Permit Number: 021198

This is to certify that Rindlaub Curtis C &/self
has permission to Build new 412 sq. Ft. detached garage / work shop
AT 639 Island Ave, Peaks Island L 092 E022001

Status: Approved with Conditions

1st FLOOR FRAMING PLAN + FOUNDATION PLAN
 SCALE 1/4" = 1'

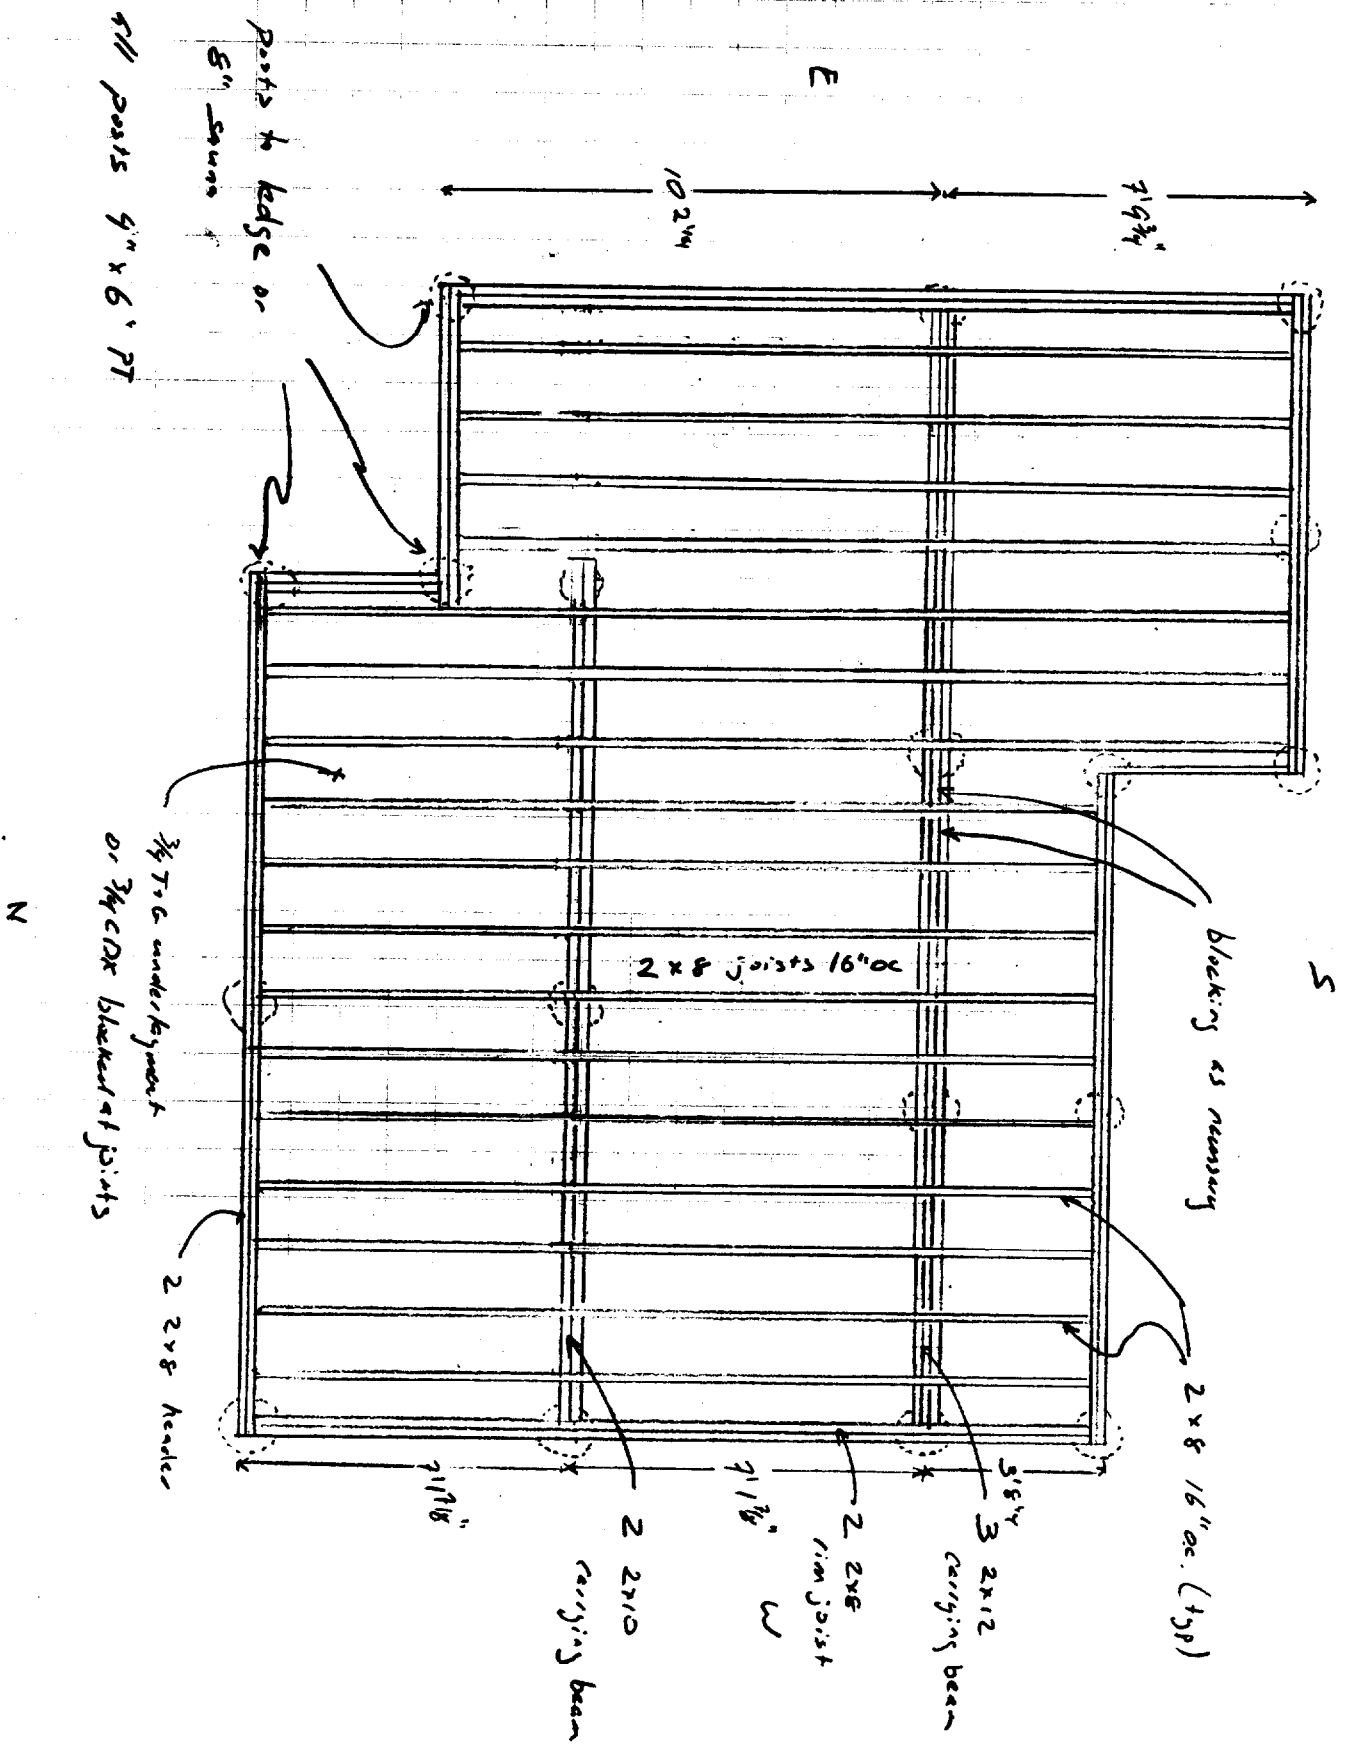
An additional pier is required in the north carrier MJN
